AQUIND Interconnector  
Relevant Representations of Natural England

Planning Inspectorate Reference: EN020022

19 February 2020

## NATURAL ENGLAND'S RELEVANT REPRESENTATIONS IN RESPECT OF AQUIND INTERCONNECTOR

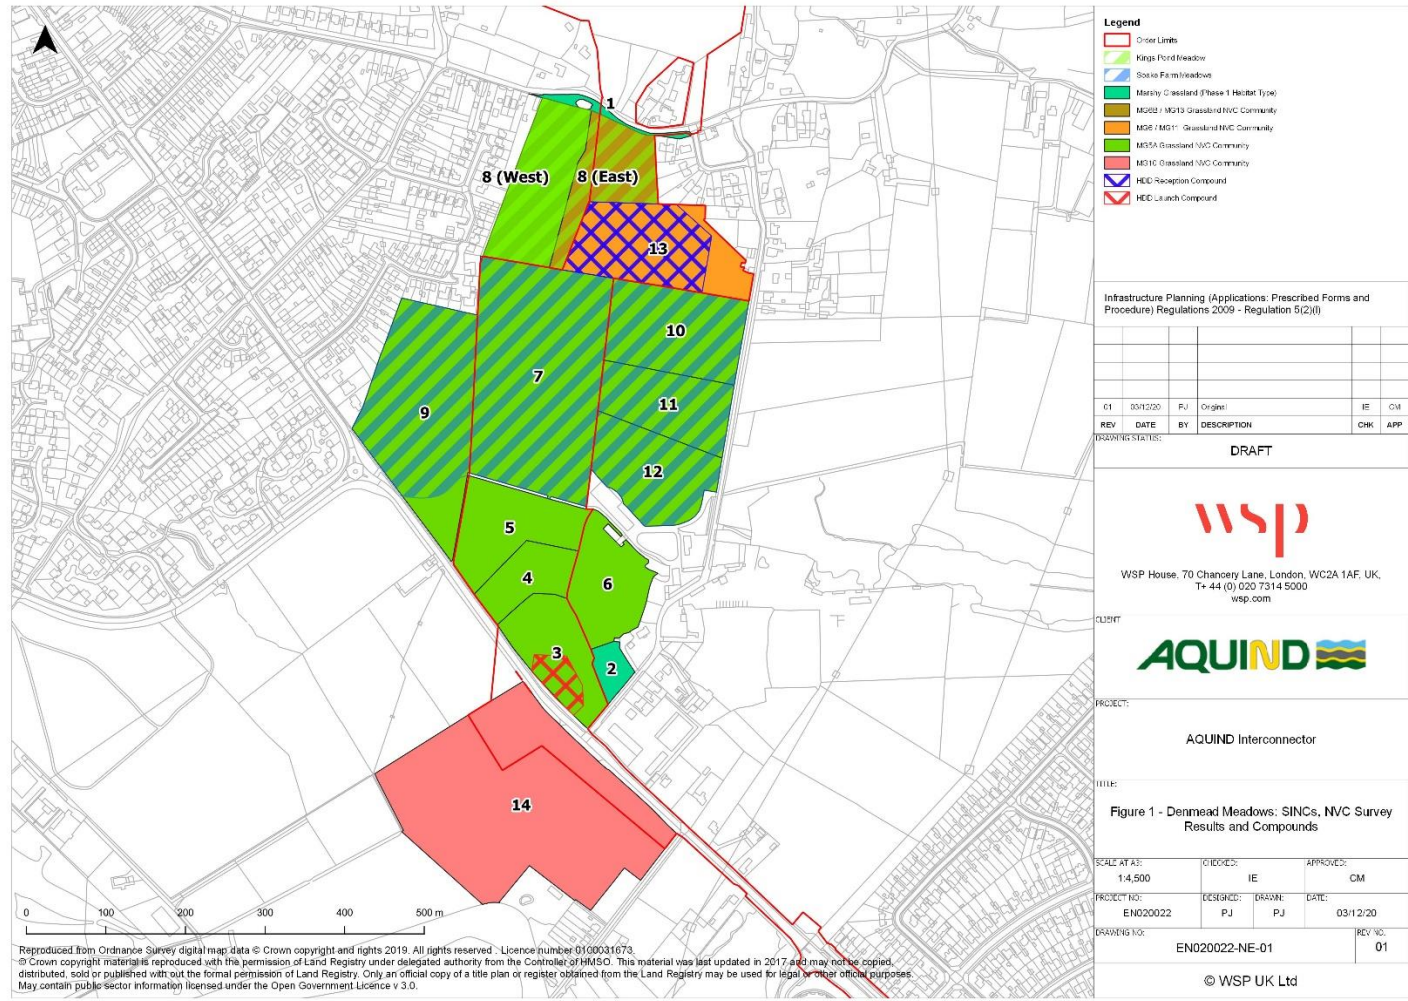
However, Natural England is concerned that the location of the construction compound, jointing bay and section of cable to be trenched across these meadows will result in damage to this priority habitat and a residual loss of biodiversity. Further information is requested to inform the mitigation measures and compensation measures, as necessary.

Natural England has concerns about the scale of the impact of the proposals on Priority Meadow 3 in relation to the construction compound. We also have concerns about the impact of the jointing bay and trenched section. It is our initial view that whilst poor management of some of the King's Pond area fields (heavy horse grazing) has led to signatures of improvement that capacity for restoration to MG5 remains.

- A timeline of the schedule of works to take place on Meadow 3 (compound) including the pre translocation seed collection, removal of the turves and sub soil, preparation of the compound and proposed reinstatement of the turves and meadow following completion of construction works. The length of time that the turves are stored will influence the likely success of this strategy. We strongly recommend that the time and working footprint are minimised as far as possible.

- Location and methods for the storage and maintenance of the turves during this process. The storage of the turves may lead to further damage of sensitive habitat

Figure 1 – 2019 NVC survey results, field numbering and HDD5 reception compound.

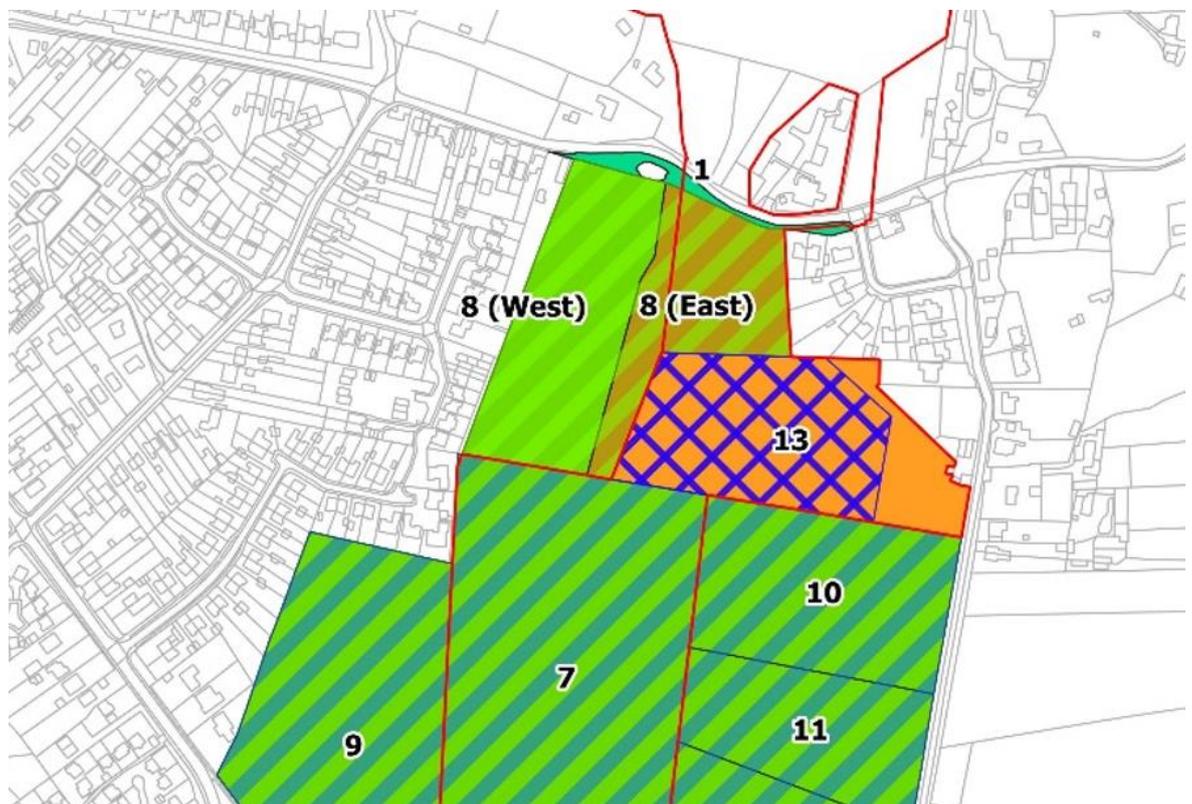
- We advise that the detailed method statement is agreed and secured and an ecological clerk of works is present during this work.
- Further information on proposed long term management of the fields to ensure the success of the translocation. Case studies have shown that the likely success of this approach is linked to how the habitat is managed after translocation. We therefore advise that a long term management strategy for the wider Denmead meadows and King's Pond SINC is secured to ensure there is no residual loss.
